CITY OF ALBUQUERQUE

March 3, 2017

RE: Peter Piper Pizza
Grading and Drainage Plan
Engineer's Stamp Date 2-17-2017 (File: J22D012D)

PROJECT TITLE PETER PIPER PIZZA 1000 JUAN TABO BOULEVARD NE ALBUQUERQUE, NEW MEXICO 87112	DRAWN BY: JEFF WOOTEEN	JOB NO. 2016041	SHEET TITLE Grading Plan
DATE 12/25/16	SCALE AS NOTED	SHEET C1.1	OF 1

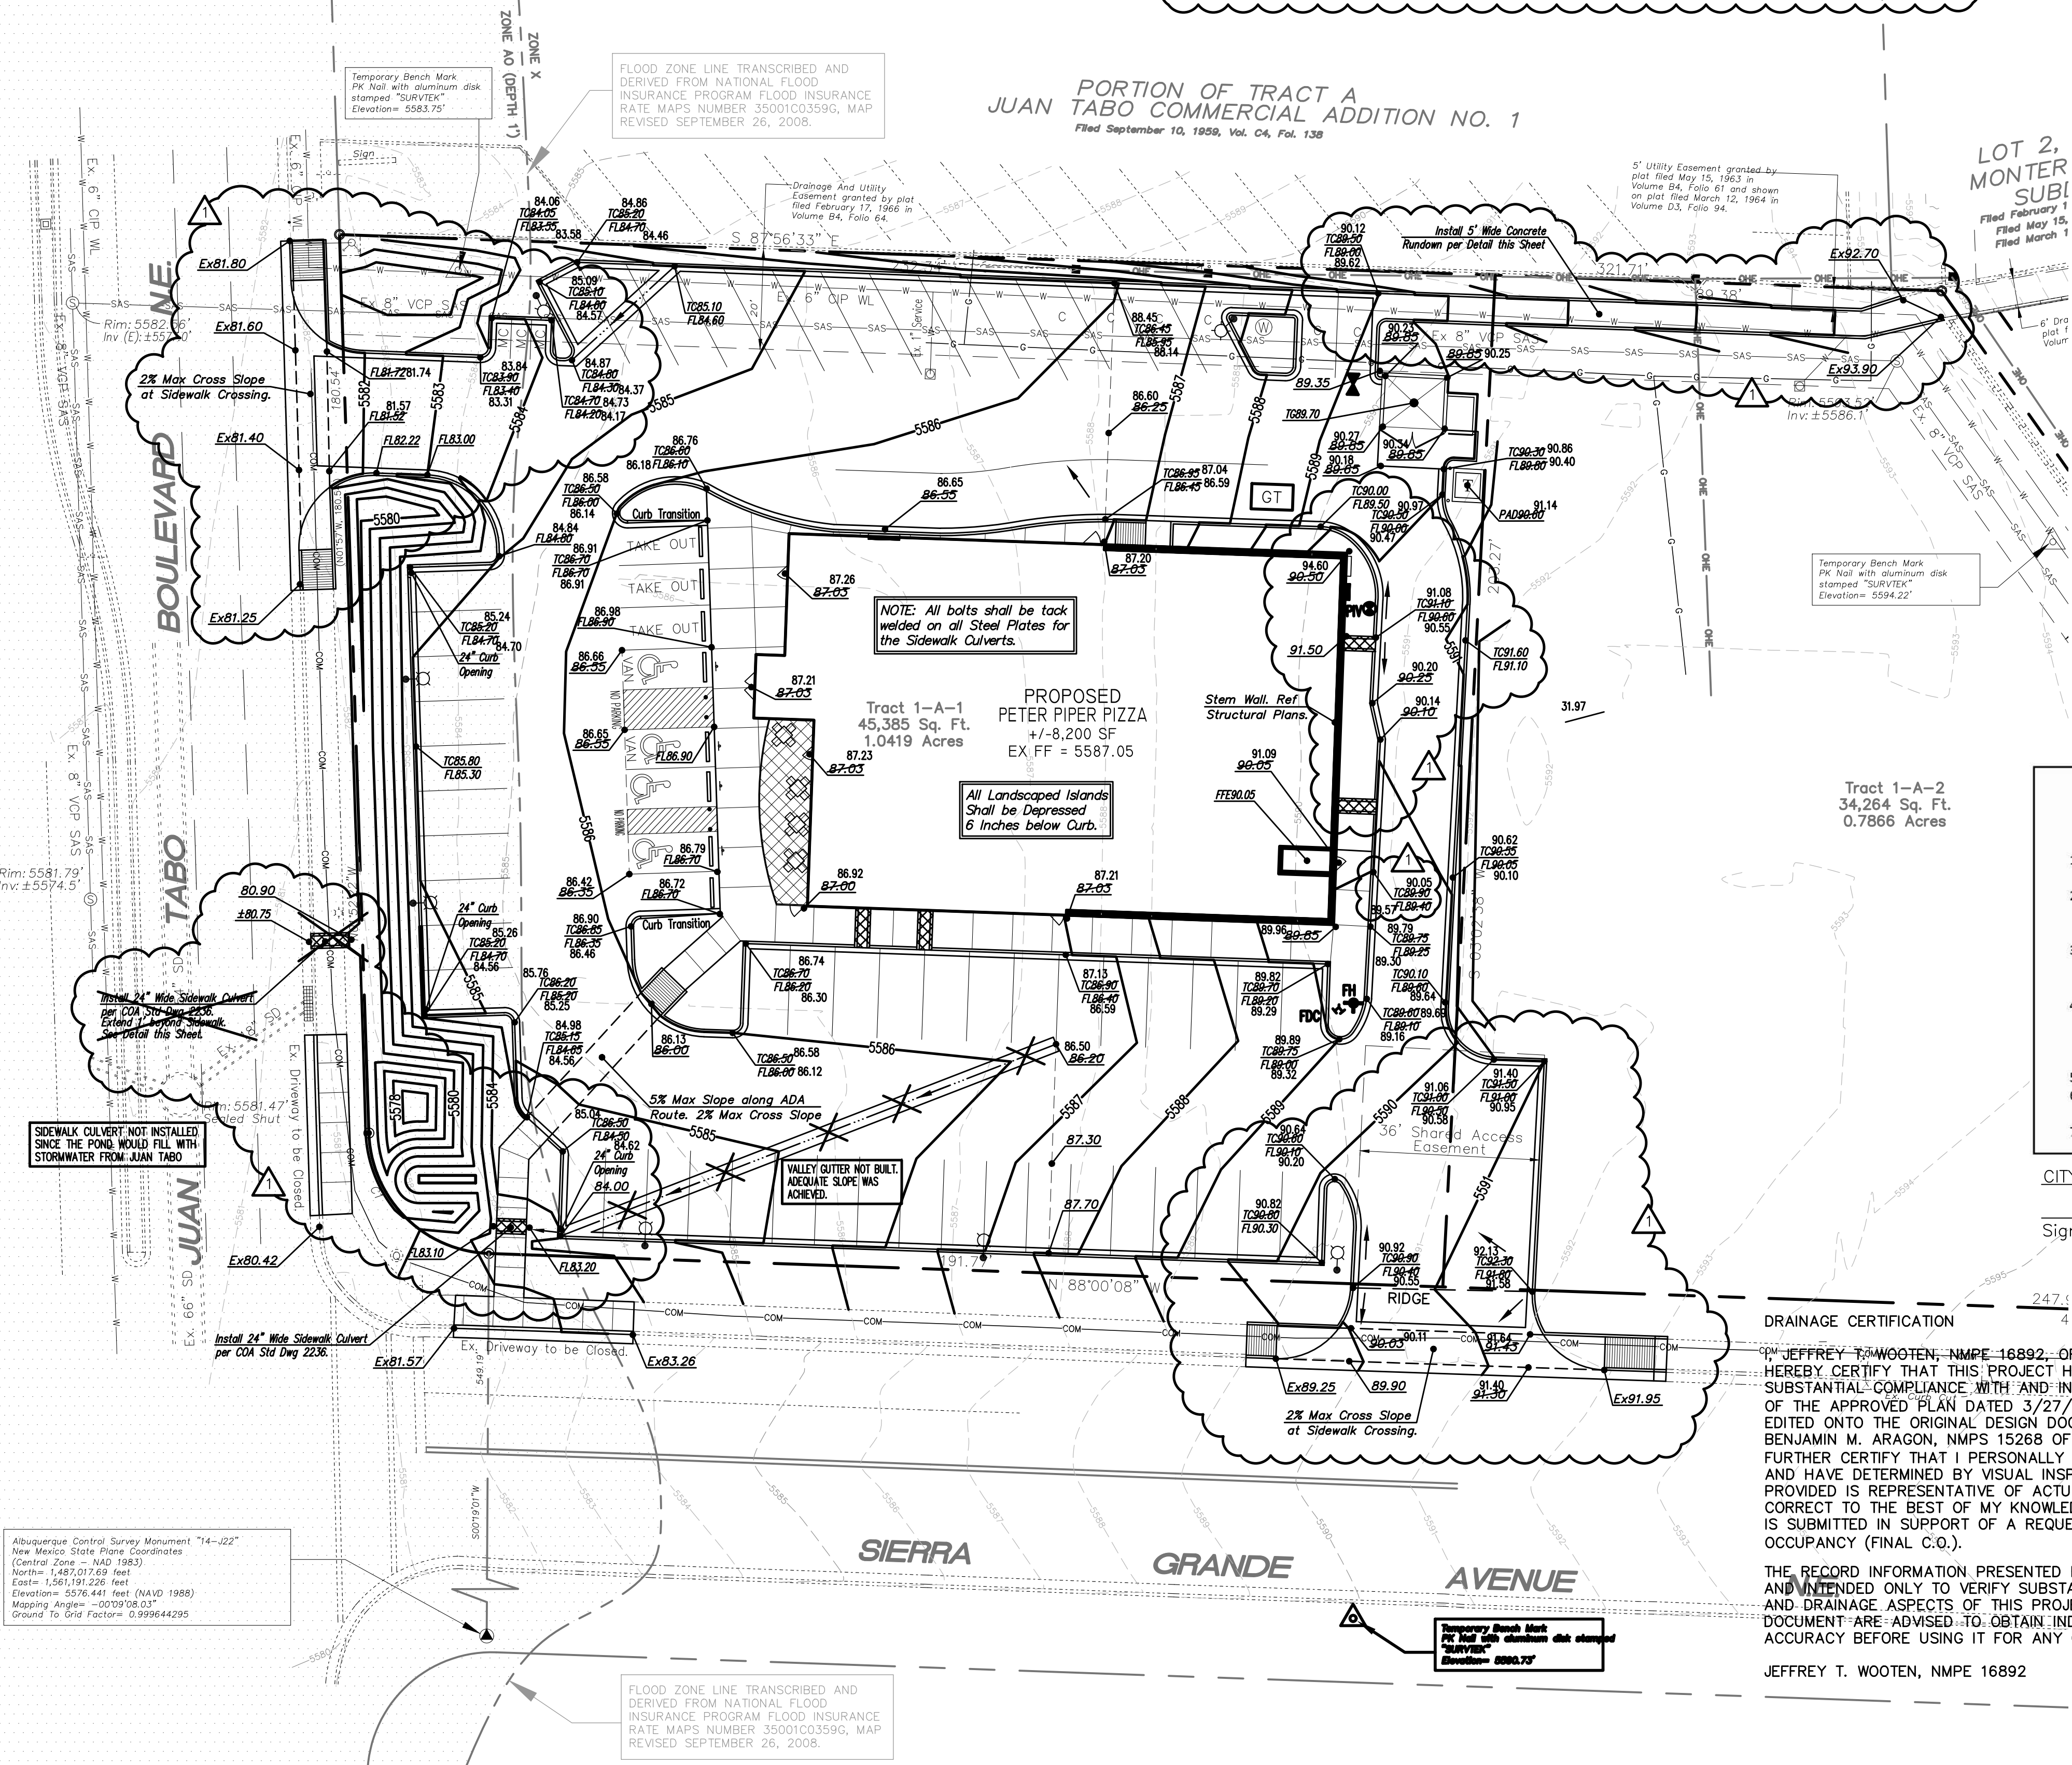
1. Show how run off will drain into the street via sidewalk culvert.
2. Extended sidewalk culvert plate 1 foot behind the sidewalk.
3. Provide inverts for the sidewalk culvert.
4. Tack weld bolt at the sidewalk culvert plate.
5. The northerly ramp at the entrance on Juan Tabo Blvd cannot be front of another property.
6. Provide drain with grate elevation for trash enclosure that drains to grease trap then to SAS.
7. Provide calculations for 12 inches PVC SD on the southwest corner of the site.
8. We recommend sidewalk culvert instead of 12 inches PVC under the sidewalk.
9. Provide sidewalk culvert capacity calculation.
10. ESC plan must be approved prior to building permit.
11. Attach copy for Floodplain permit.
